**From:** Denise Preisser <dpreisse@maine.rr.com>  
**To:** Jean Fraser <JF@portlandmaine.gov>  
**Date:** 2/6/2016 8:36 PM  
**Subject:** Re: 31 Fore Street

Hello Jean,  
Thank you for keeping me up to date on the plans of 31 Fore Street.

RESIDENTIAL MULTI-UNIT STUDY
31 FORE STREET

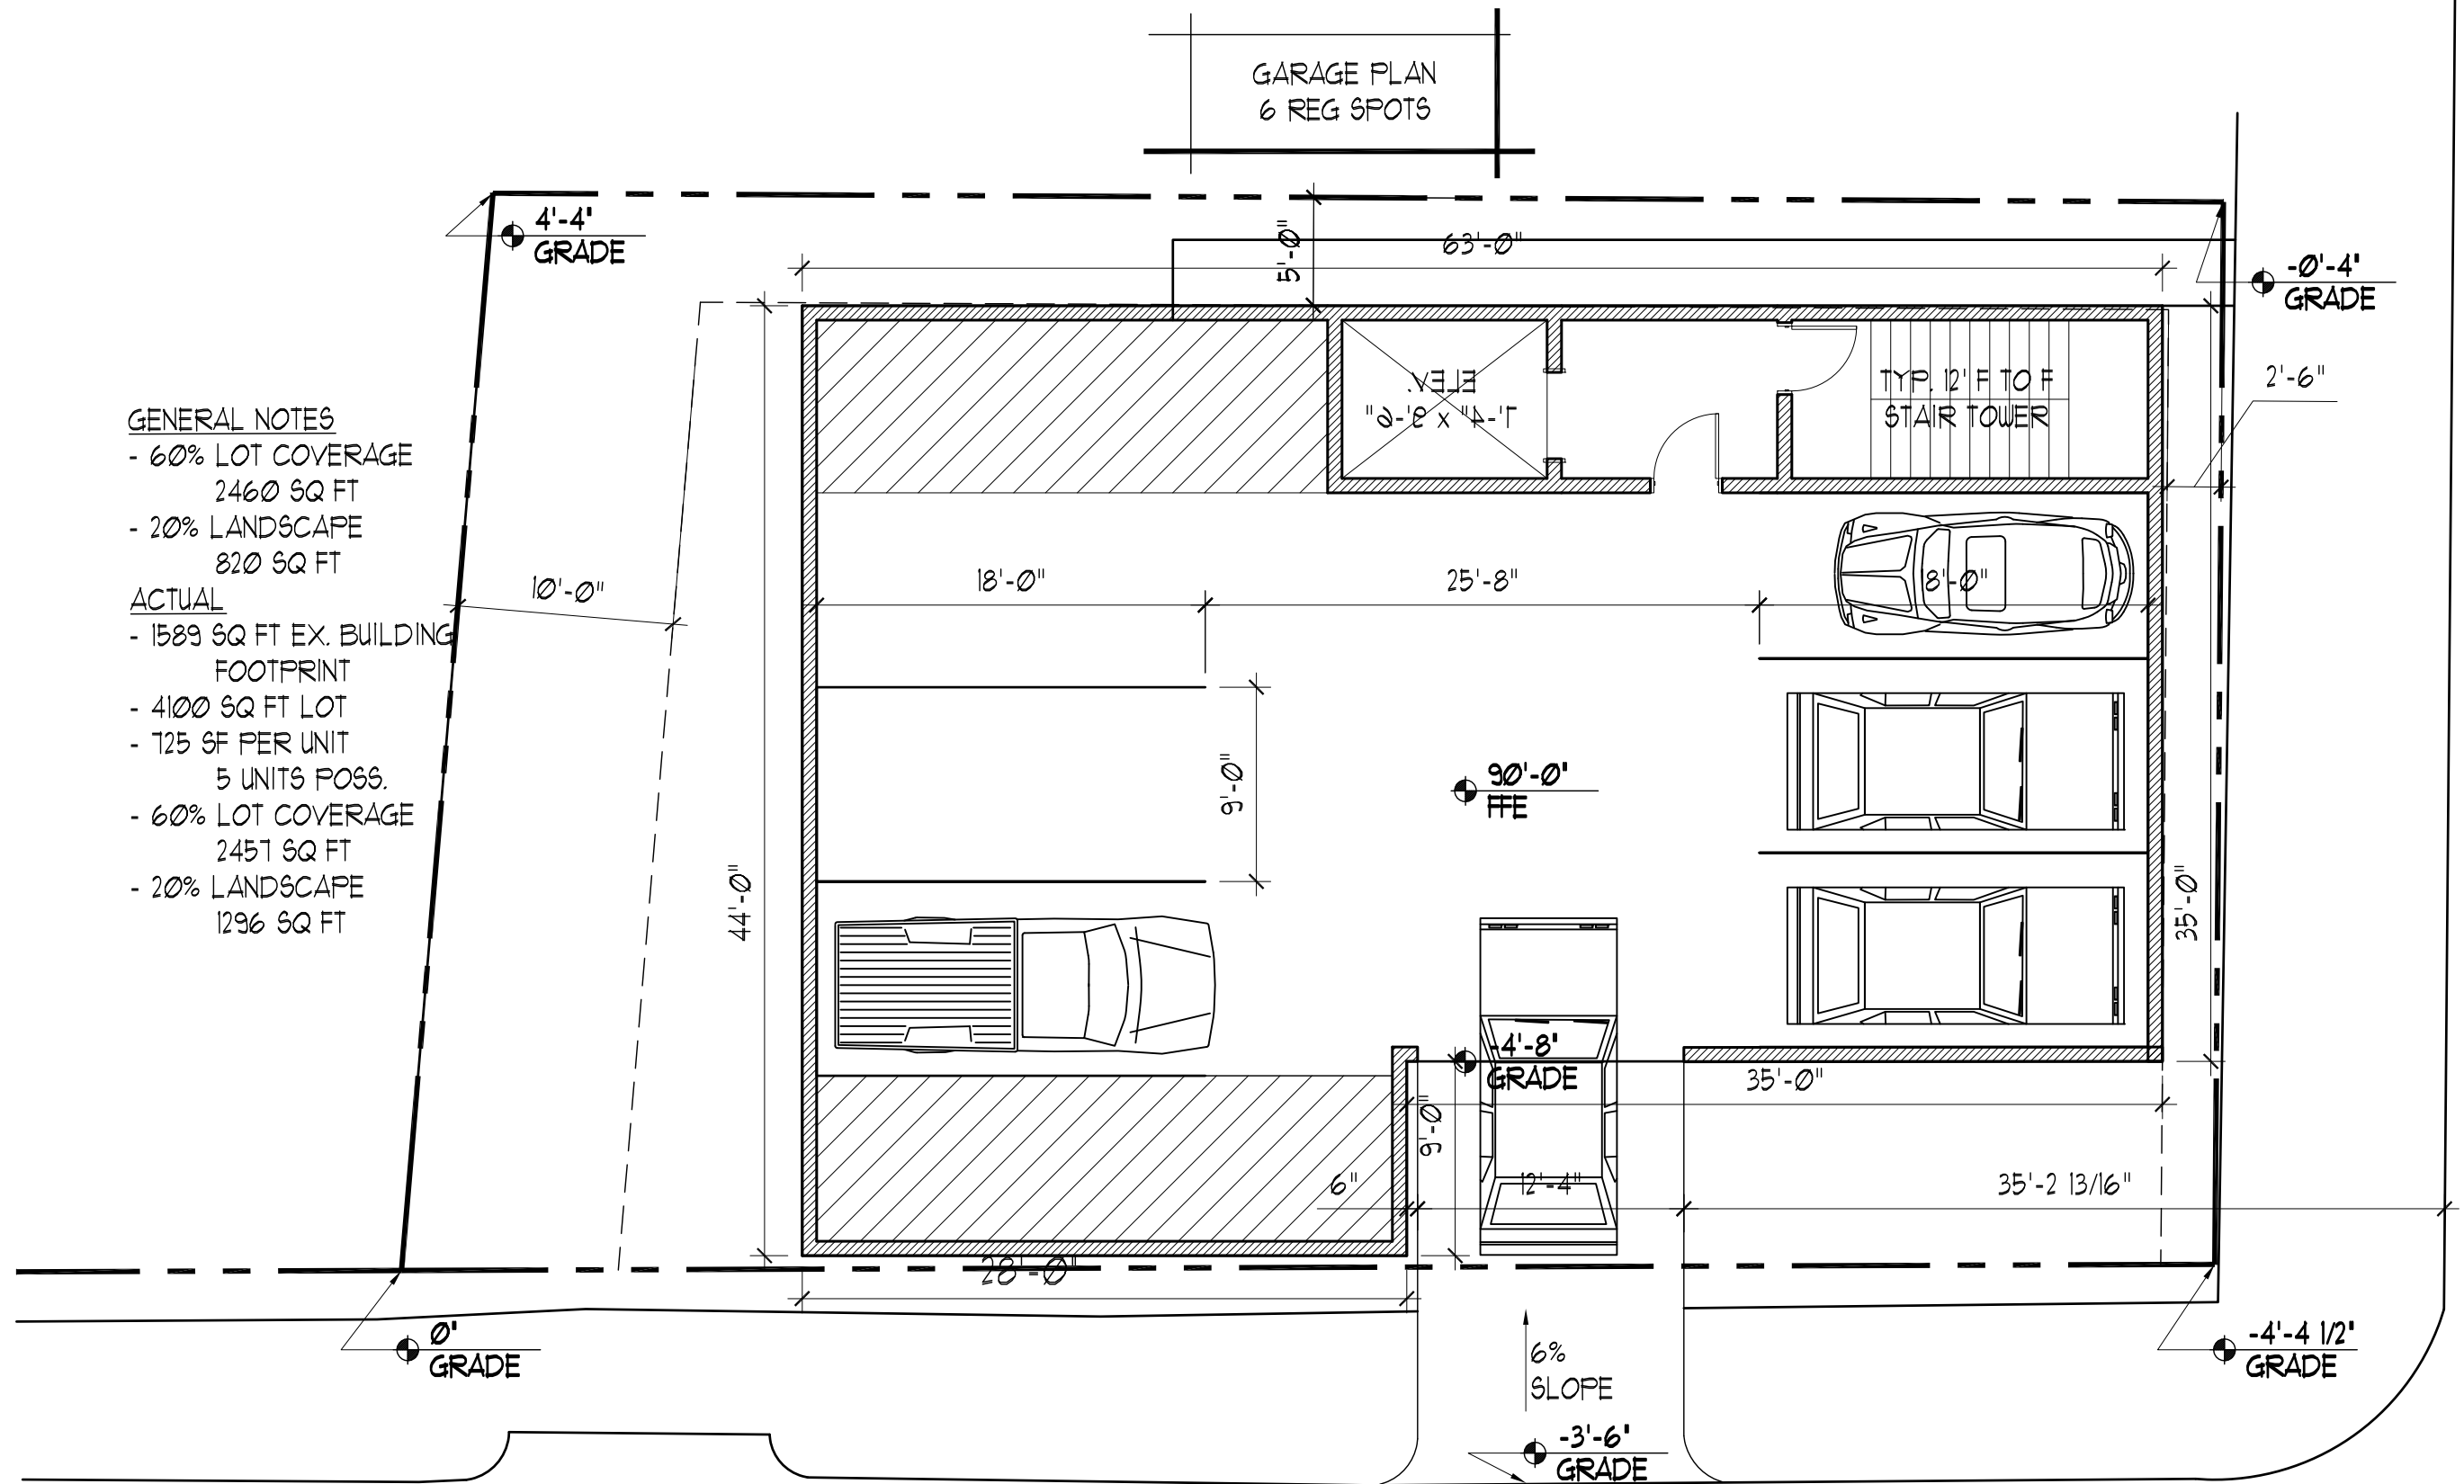
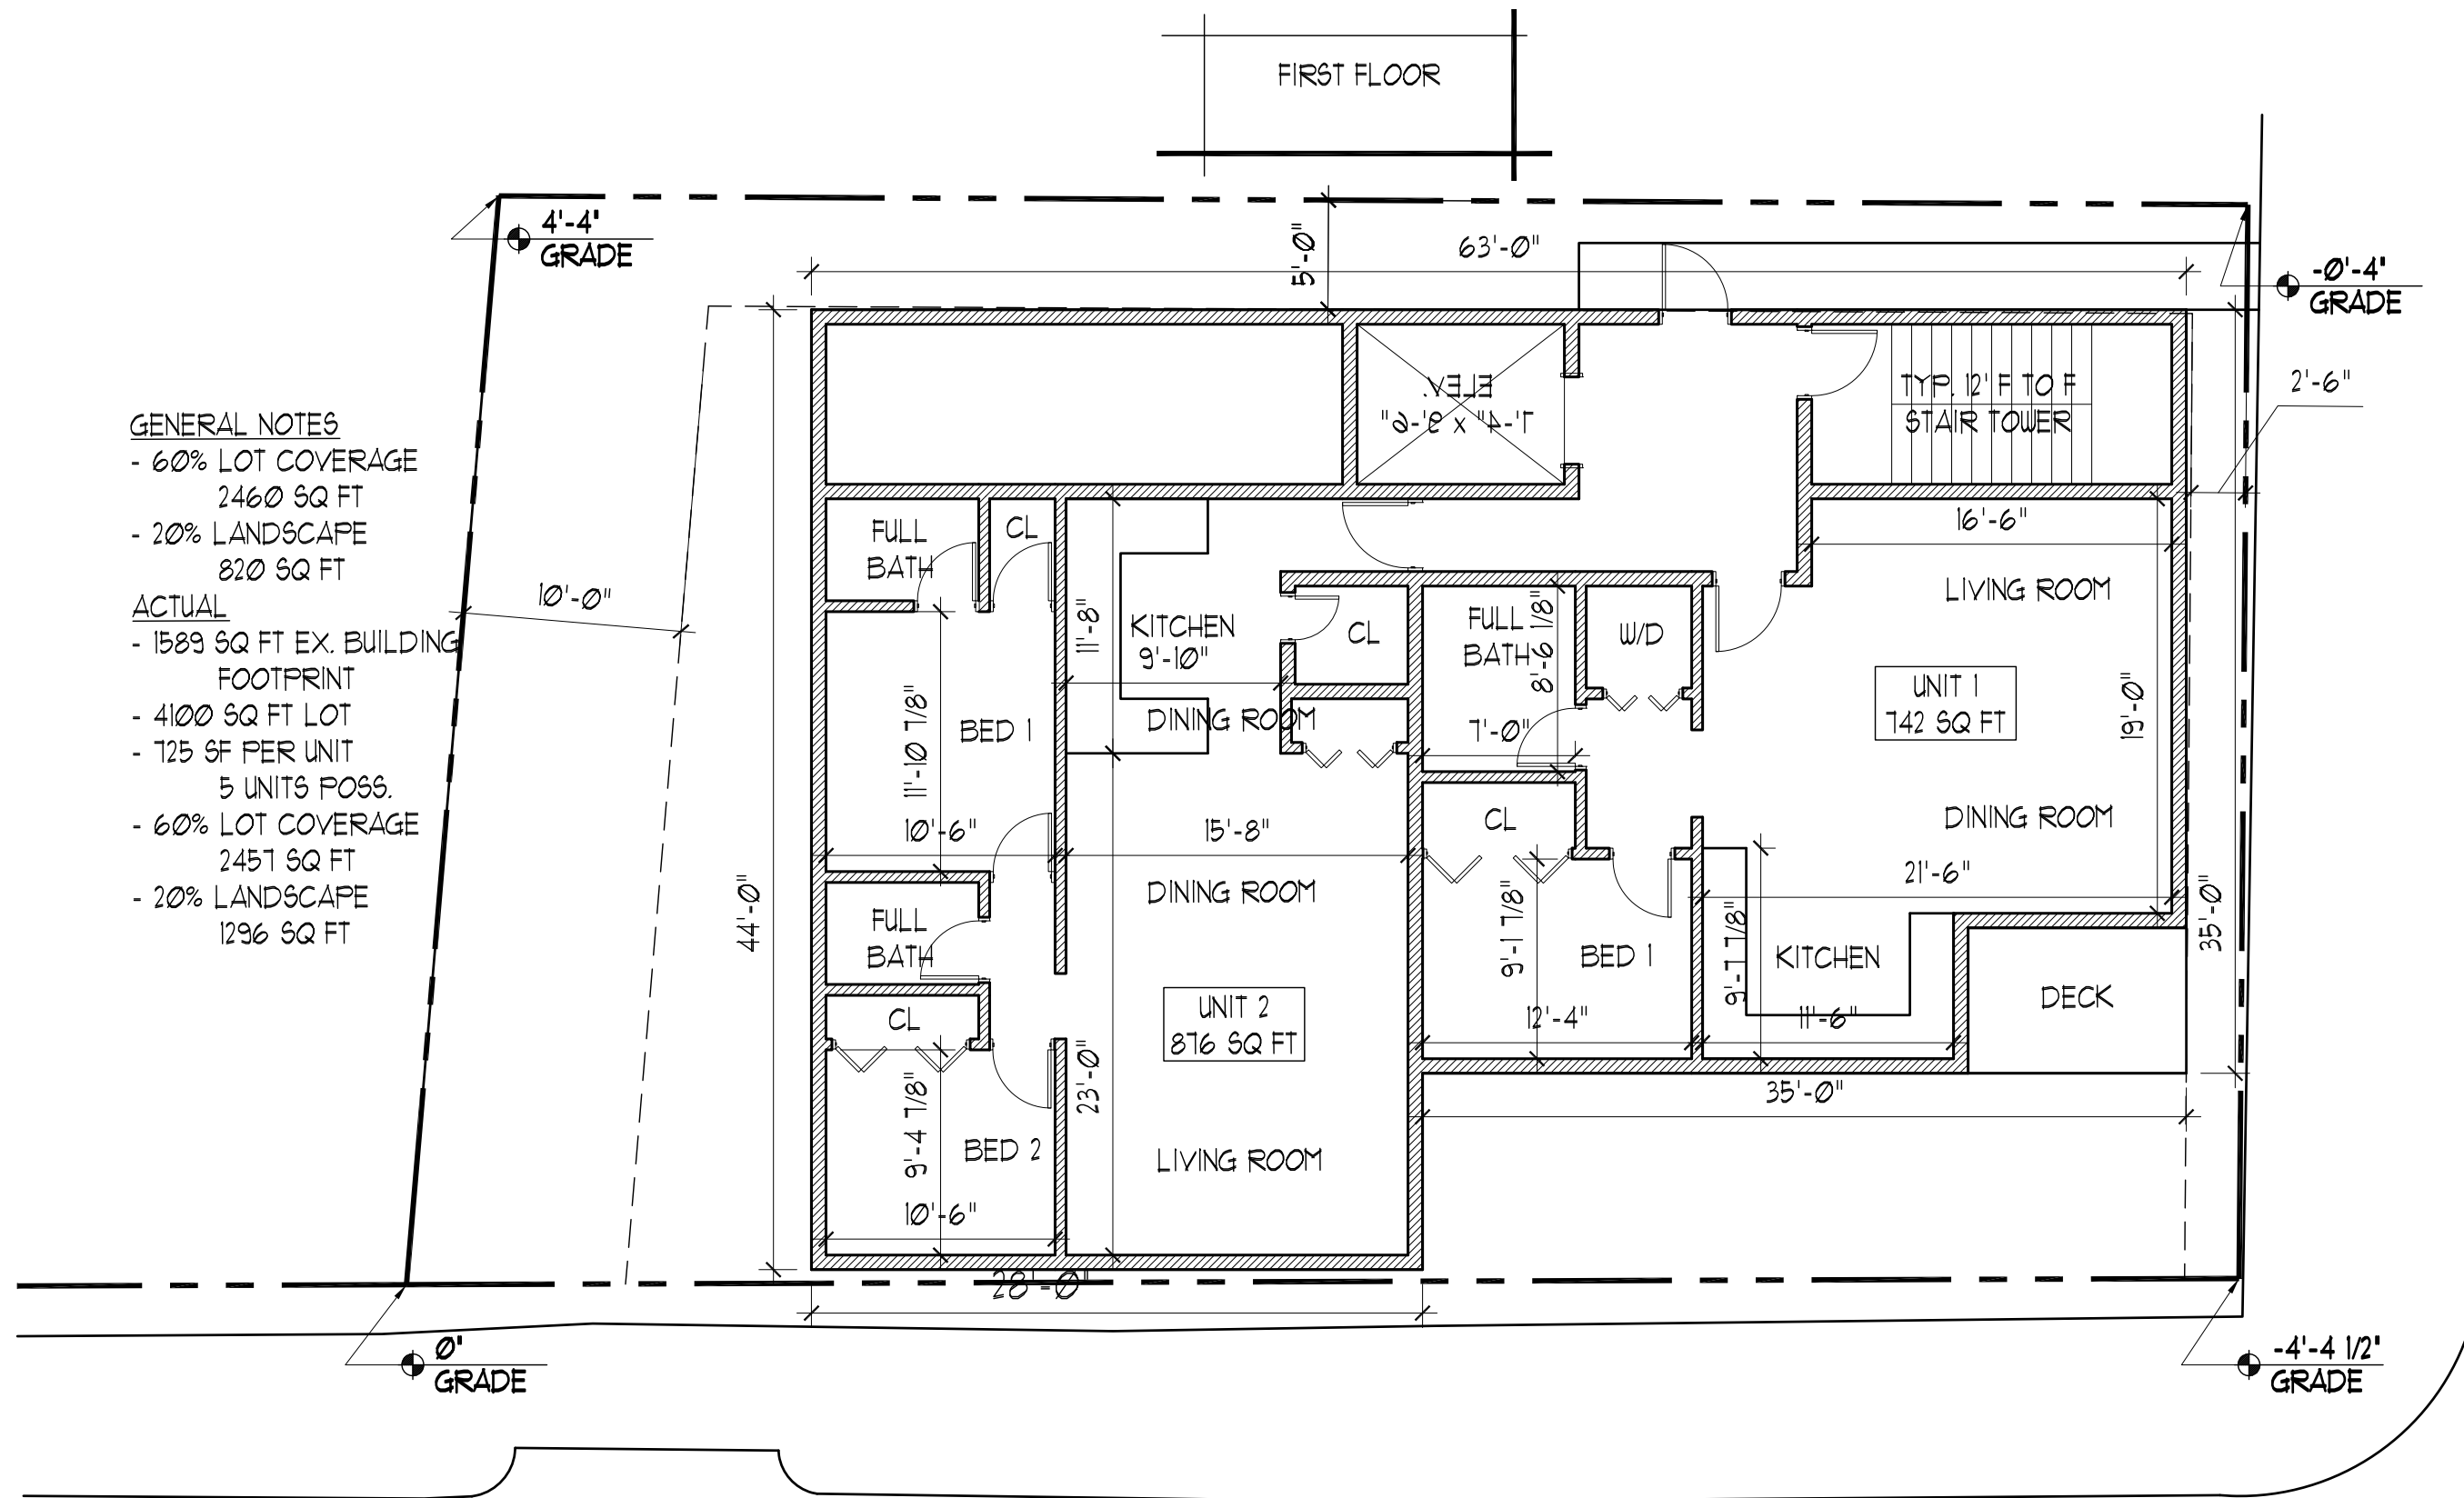
- The limited number of windows on the side of the building abutting the 25 Fore Street condo and garden pathway is a real plus. The buildings are so close and this new design provides privacy for both buildings. As I interpret the plans the windows on this side will be only be for stairs and landings for each floor.

- The visitor/delivery entrance abutting 25 Fore Street property line does not seem to be an effective screening for privacy for 25 Fore decks and garden area. At this time our space is gated for security and privacy and this plan looks like anyone could walk up this side entrance and have access to our property. I want to make sure the developer makes provisions to compliment both properties, but also maintain the privacy and security for 25 Fore property that now exists. My first choice would be not to have an entrance on this side however, if that can not be addressed, I suggest fencing be added to define secure our property lines (like we currently have) and/or vegetation added that enhances the 5 foot space to be added the length of the building with the new footprint of this building.

- The curb appeal of the ground front and parking side areas needs special attention. This is a massive amount of siding that is a great wall for graffiti. Vegetation would enhance this since so much green space is being lost with this new building filling in grass area to the sidewalk.
